From: Brendan.M Hurley <Brendan.M.Hurley@fire.nsw.gov.au>
Sent: Thursday, 15 October 2020 2:58 PM
To: Emma Barnet
Cc: Fire Safety
Subject: HPE CM: Kings Park Metal Recovery and Recycling Facility Expansion (SSD-10396). BFS20/3013

Kings Park Metal Recovery and Recycling Facility Expansion (SSD-10396)

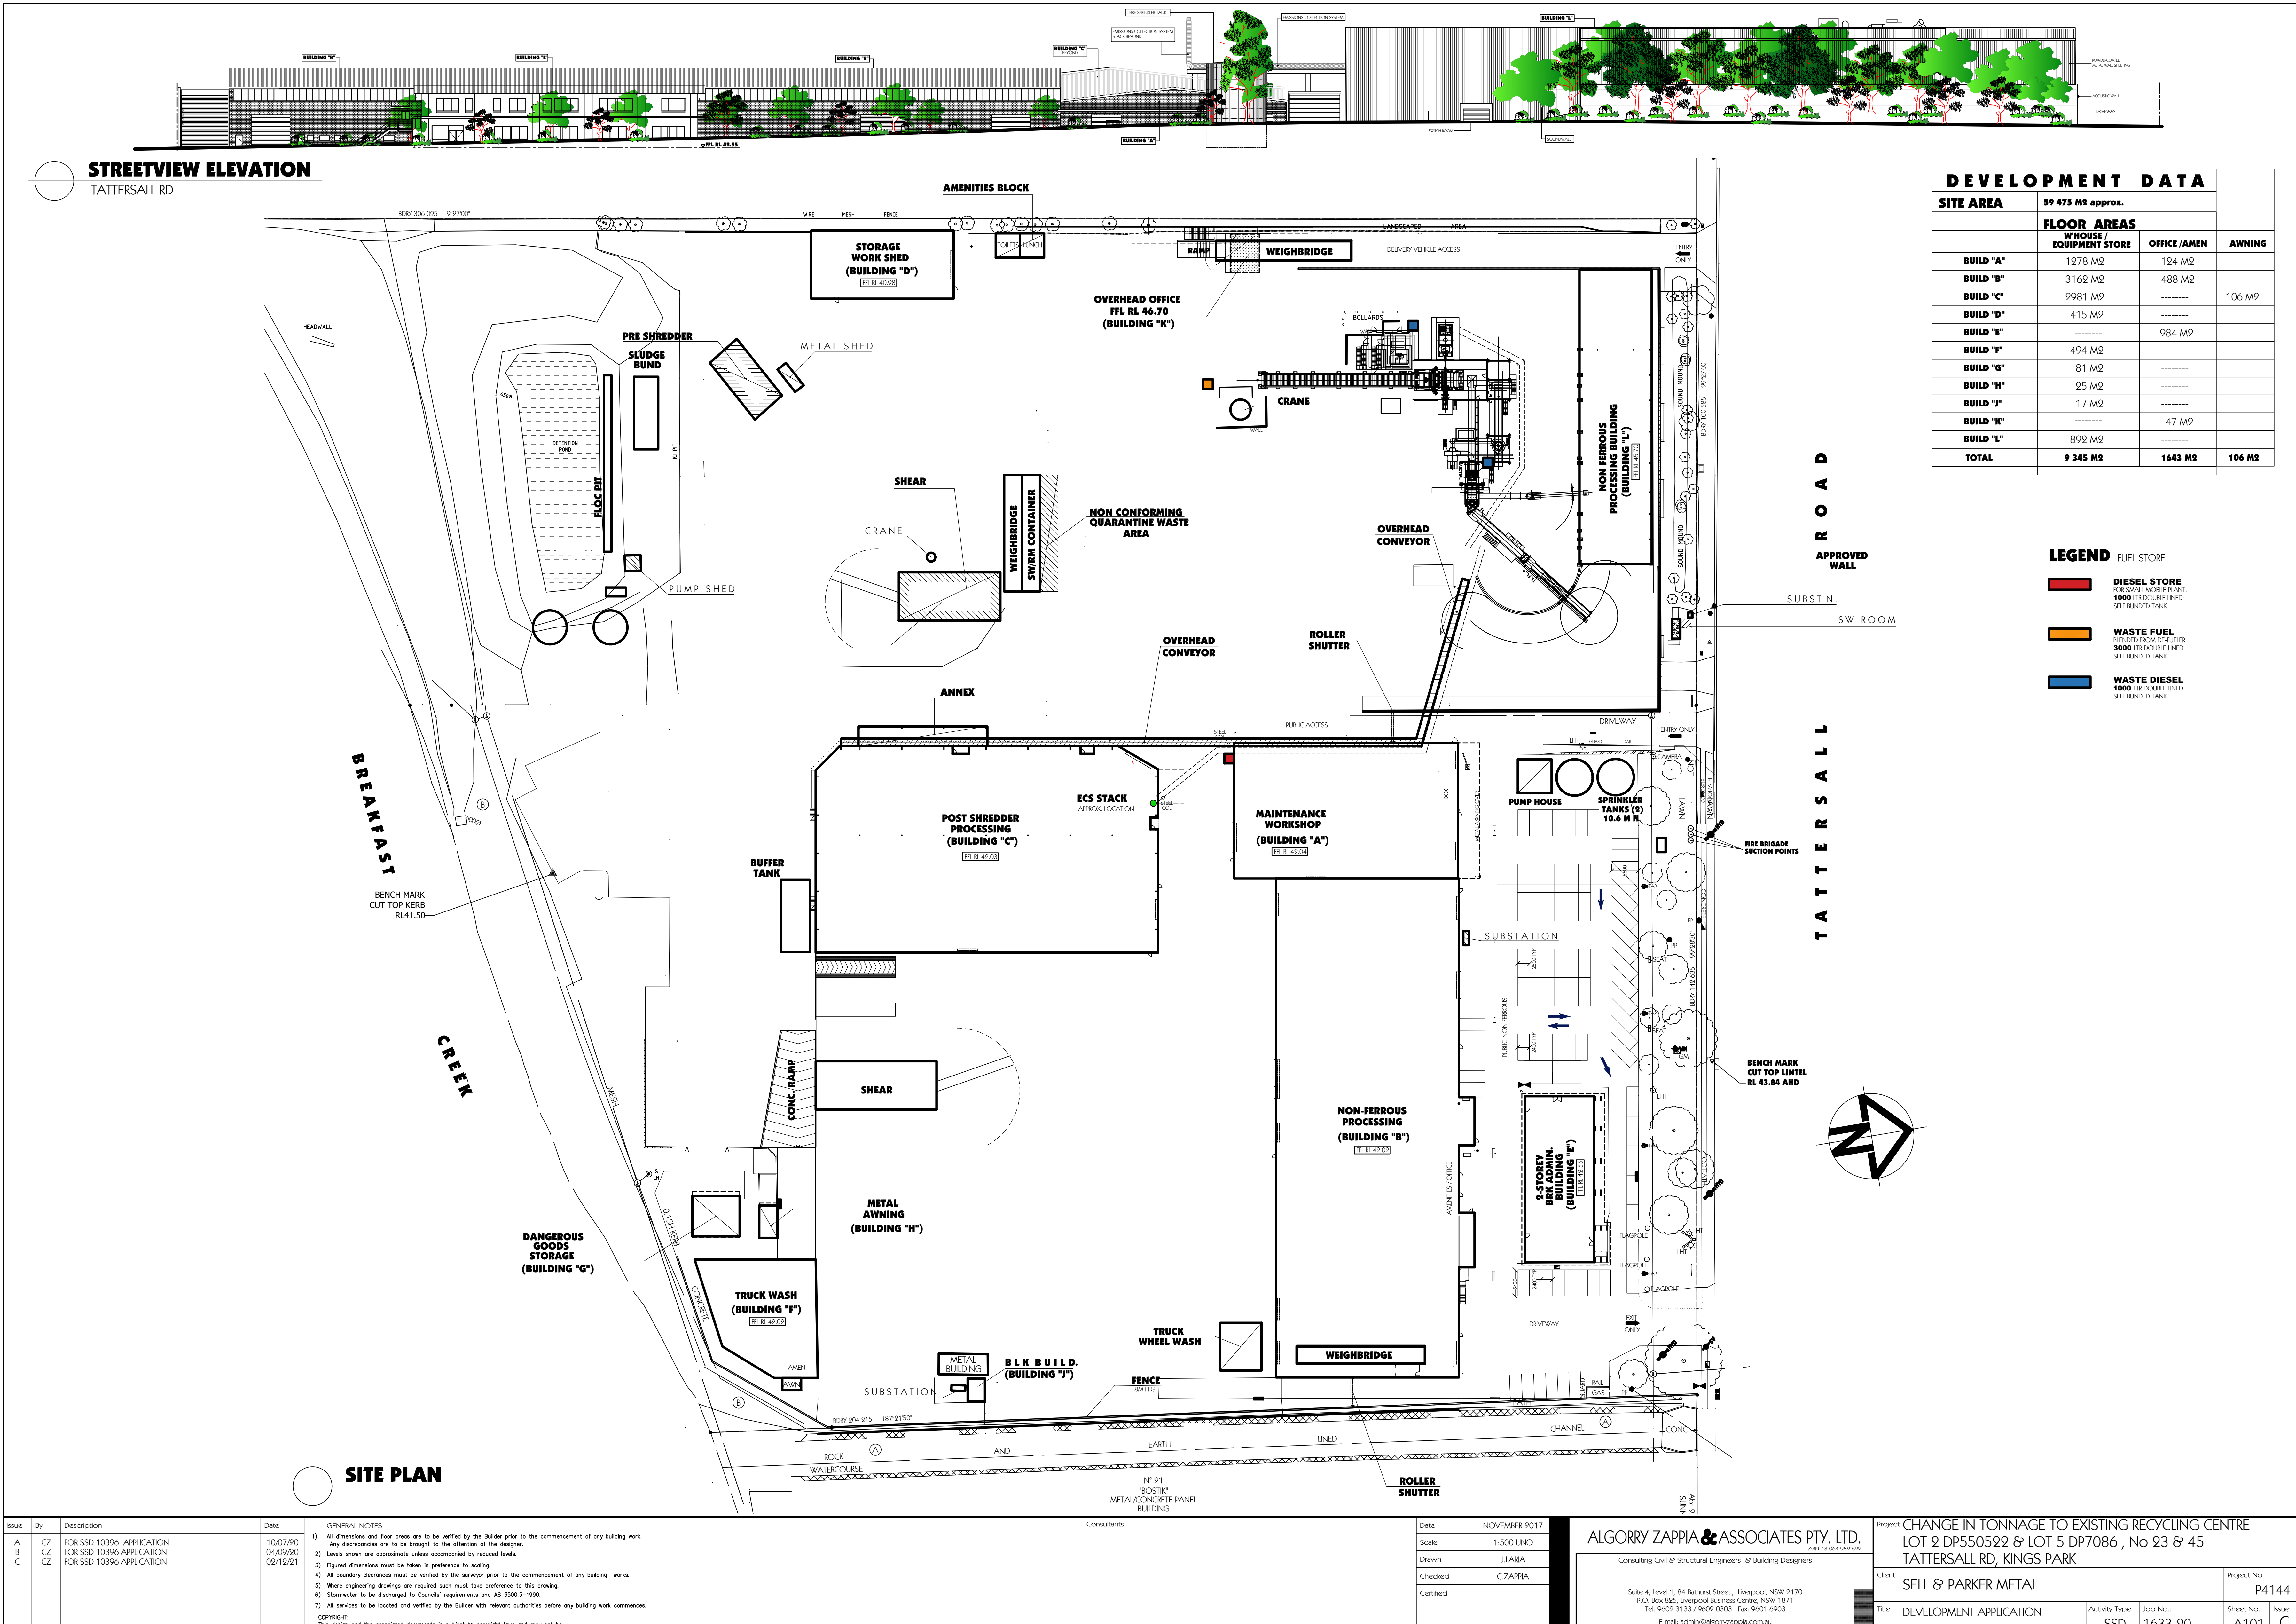
- FRNSW are satisfied with the stockpile height and separation as per the plans submitted on the 12th of October 2020.
- FRNSW note that screening under SEPP33 was conducted and the site is deemed potentially hazardous or offensive. As per page 73 of the EIS report *"The assessment found no potentially hazardous or dangerous goods would be stored on-site that would exceed the prescribed thresholds outlined in Applying SEPP 33, and that a PHA was not required for the Proposal"*.
